**EL PASO COUNTY PLANNING AND  
 COMMUNITY DEVELOPMENT  
 DEPARTMENT**

**GRADING AND EROSION CONTROL PLAN CHECKLIST**

PPR 000

EL PASO COUNTY, STATE OF COLORADO GRADING & EROSION CONTROL PLAN

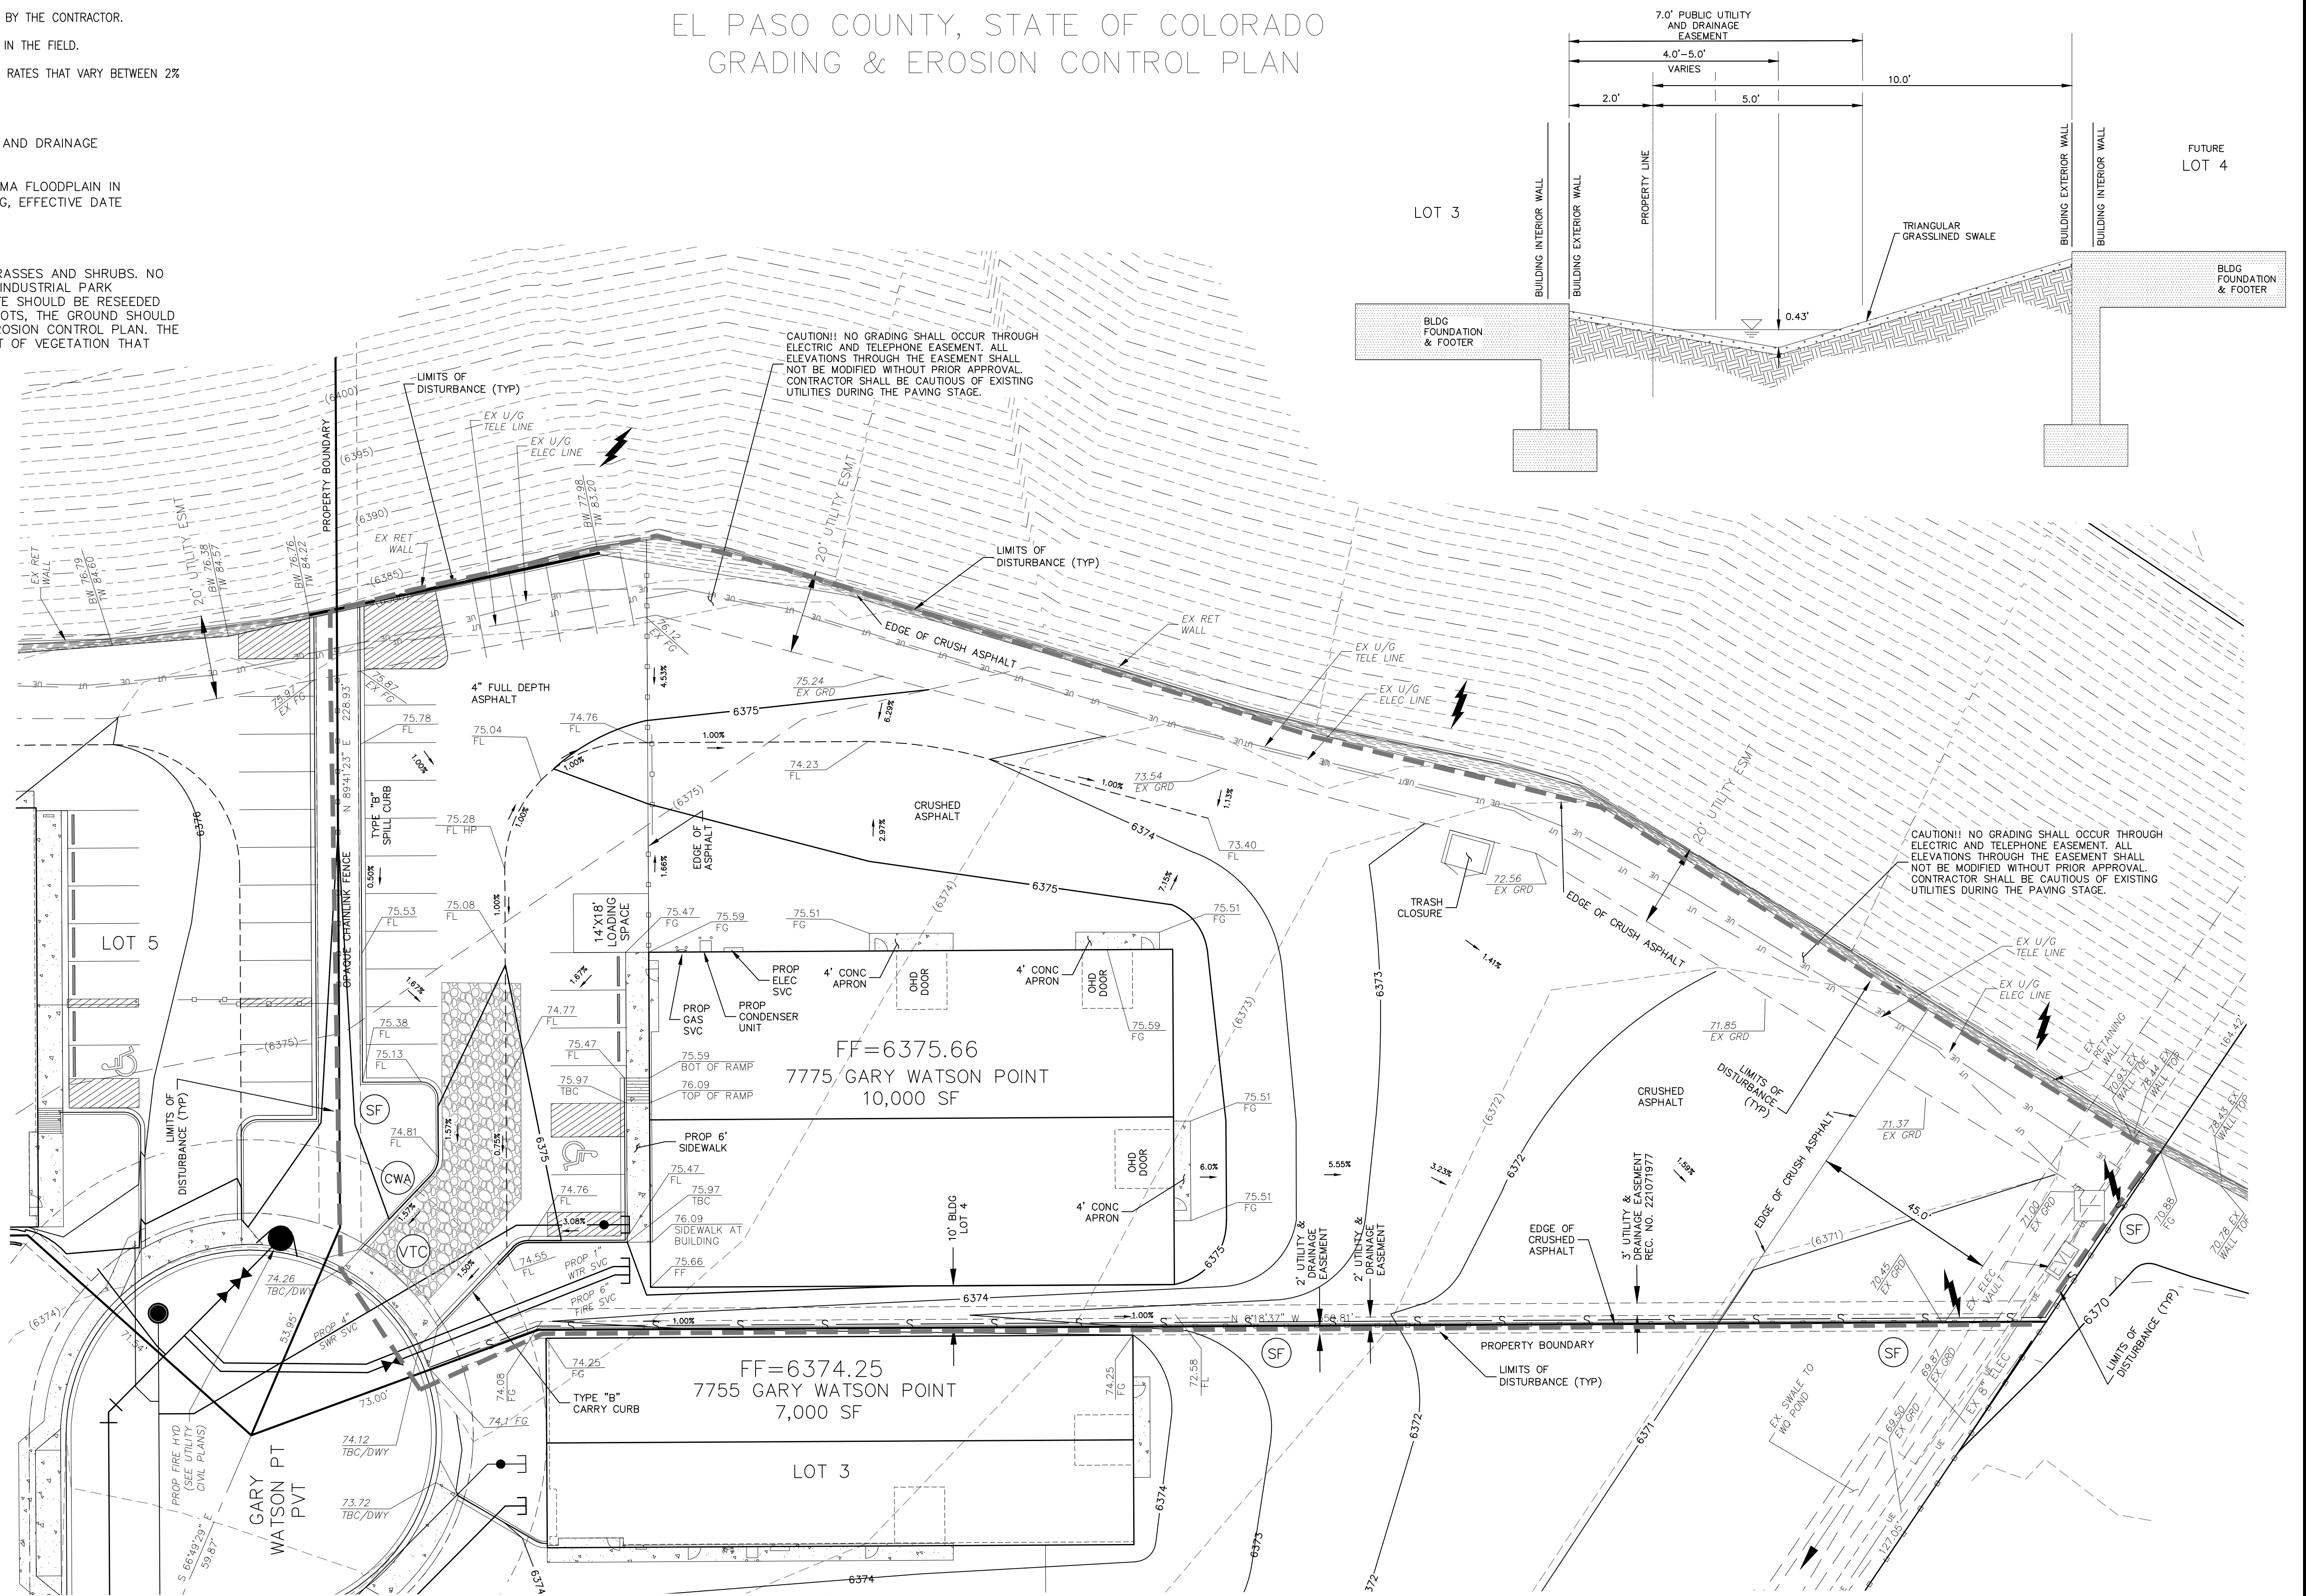
Applicant	PCD
<b>1. GRADING AND EROSION CONTROL PLAN</b>			
a	Vicinity map.	X	✓
b	Adjacent city/town/jurisdictional boundaries, subdivision names, and property parcel numbers labeled.	X	✗
c	North arrow and acceptable scale (1"=20' to 1"=100').	X	✓
d	Legend for all symbols used in the plan.	X	✓
e	Existing and proposed property lines. Proposed subdivision boundary for subdivision projects.	X	✓
f	All existing structures.	X	✓
g	All existing utilities.	X	✓
h	Construction site boundaries.	X	✗
i	Existing vegetation (notes are acceptable in cases where there is no notable vegetation, only grasses/weeds, or site has already been stripped).	X	✗
j	FEMA 100-yr floodplain.	N/A	N/A
k	Existing and proposed water courses including springs, streams, wetlands, detention ponds, stormwater quality structures, roadside ditches, irrigation ditches and other water surfaces. Show maintenance of pre-existing vegetation within 50 feet of a receiving water.	N/A	N/A

v	All proposed temporary construction control measures, structural and non-structural. Temporary construction control measures shall be identified by phase of implementation to include "initial," "interim," and "final" or shown on separate phased maps identifying each phase.	X	✗
w	Vehicle tracking provided at all construction entrances/exits. Construction fencing, barricades, and/or signage provided at access points not to be used for construction.	X	✓
x	Temporary sediment ponds provided for disturbed drainage areas greater than 1 acre.	N/A	✗
y	Dewatering operations to include locations of diversion, pump and discharge(s) as anticipated at time of design.	N/A	N/A
z	All proposed temporary construction control measure details. Custom or other jurisdiction's details used must meet or exceed EPC standards.	X	✓
